Subject: New comments for application 19/00895/REM

**Application Numbers:** 19/01037/REM and 19/00895/REM

Reserved matters to 15/01326/OUT - Layout, scale, appearance and landscaping for the residential development of up to 280 dwellings and 34 space car park.

OS Parcels 6741 and 5426, West of Cricket Field Nor Wykham Lane, Bodicote

Drawing Title
HARD, BOUNDARY & FURNITURE PROPOSALS (SHEET 2 OF 3)

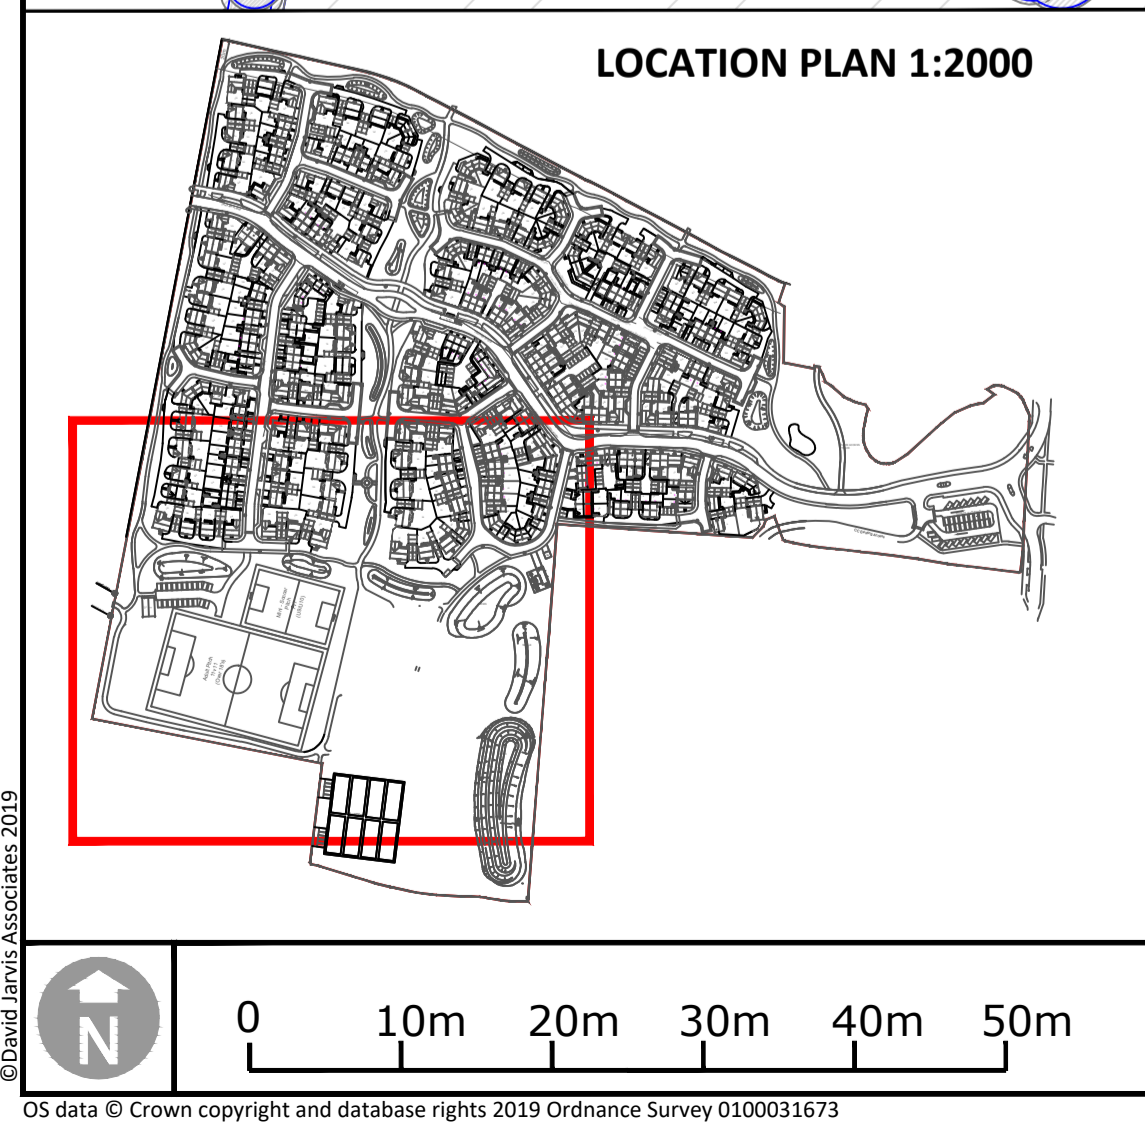
Bins are included on both layout proposals for the Central and Western Play Areas, totalling in three for the entire development. Are there plans to include additional bins near bus stops, bridleways, pitches or green open spaces?

When will bins be provided for resident use and who will be responsible for maintaining them? We are aware of existing issues regarding litter and dog faeces on the Longford Park development, due to a lack of bin provision, and would not want that replicated.
